30th April 2019

Our Ref; SP7319

Application 2018/94181 – Proposed alterations to convert hotel (C1) to 12 student studios at 31-37 Beast Market and 1 Southgate, Huddersfield HD1 1QF

SECOND FLOOR PLAN - as proposed

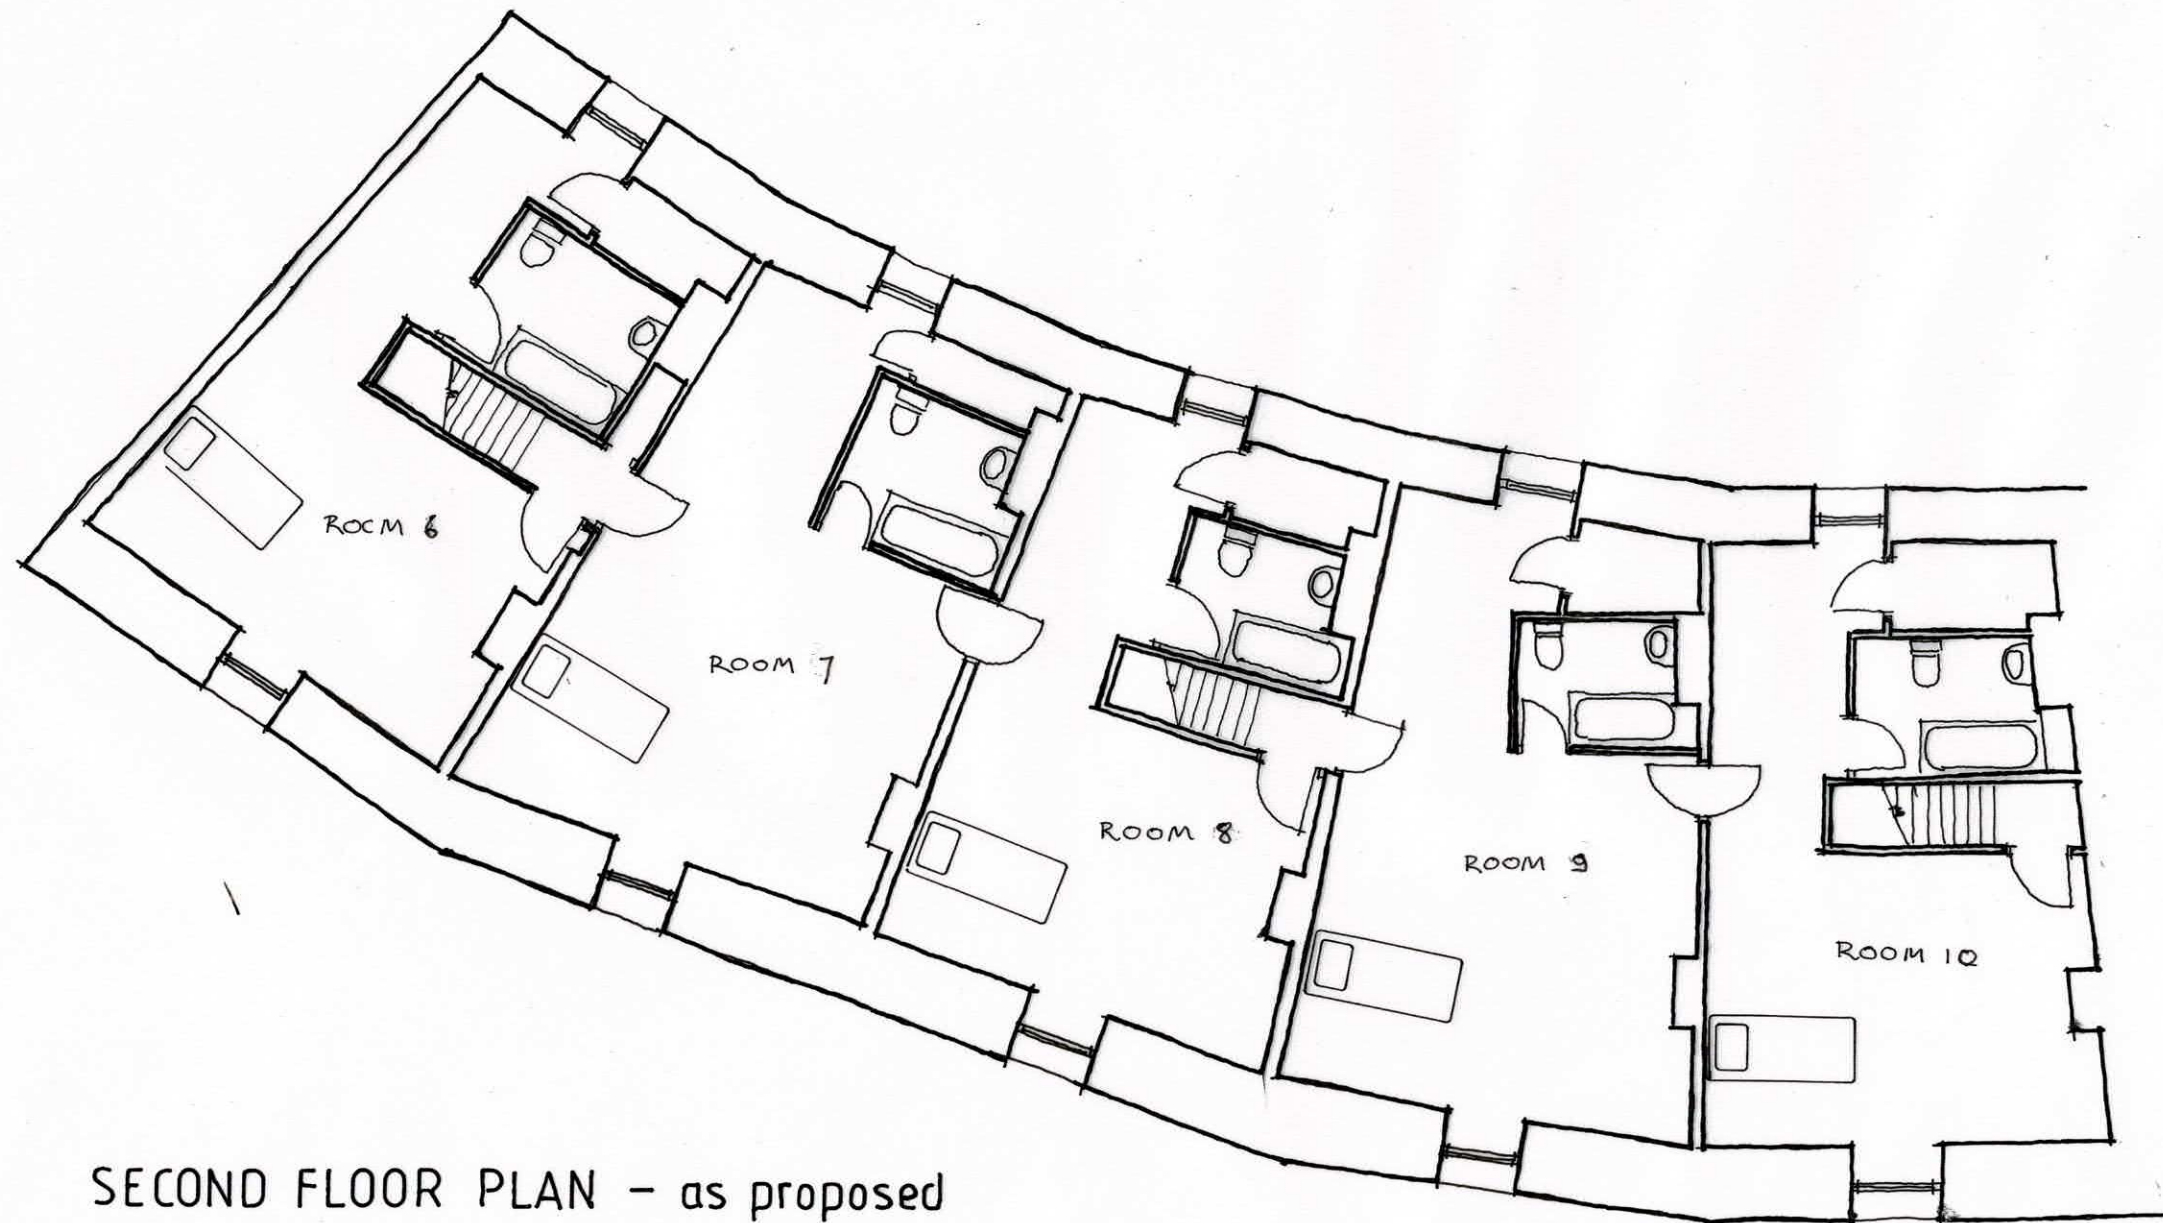
Turning to your initial concerns about the size of a few of the proposed units, we took you through comparisons with recent student accommodation approved by the Council within Huddersfield town centre. We acknowledged that room 2 at 16.10 sq m was on the small side and below the 18 sq m that had been approved for some of the rooms approved in the former Co-op building on New Street. It was agreed that we would look at some reconfiguration to see if we could improve the size of room 2. In doing so we made it clear that student accommodation should not be assessed against the nationally described space standards for residential accommodation as it is not residential in the true sense of the word with occupants not occupying it as their main residence.

Room 4 would be 19.67 sq m, room 5 21.48 sq m and room 1 23.56 sq m with the remaining units all being over 30 sq m, significantly above the floorspace of student accommodation approved in the town centre.
